Subject: 2025/91639 at location 40, Bradford Road, Fartown, Huddersfield, HD1 6JE

Please see ecological commentary below:

PROPOSED ROOF PLAN. and
LOCATION PLAN

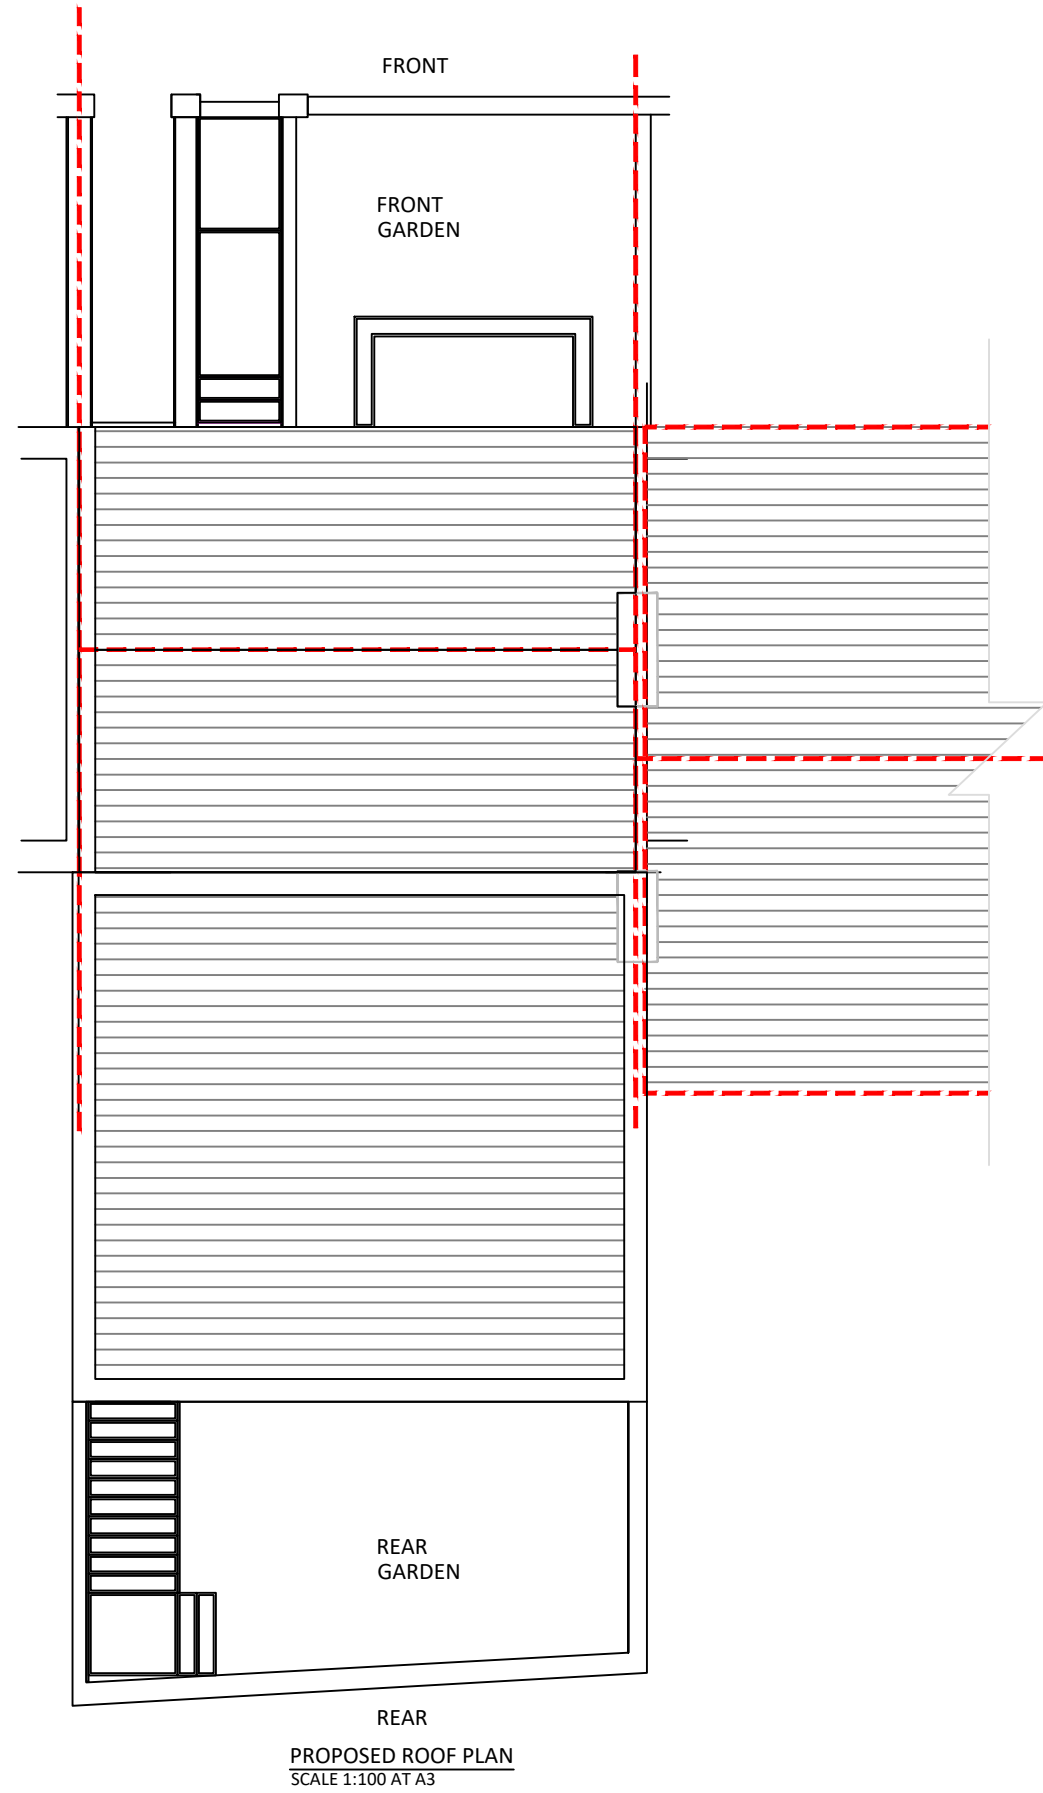
The building itself seems to have some bat roosting features (loose tiles, etc.).

Further information is required prior to decision. Several records for protected and priority species and habitats are present within 1km of the site. A retrospective Preliminary Bat Roost Assessment is therefore required prior to decision to assess the site habitats, the likely presence of protected and/or priority species, and the value of site habitats to protected and/or priority species.
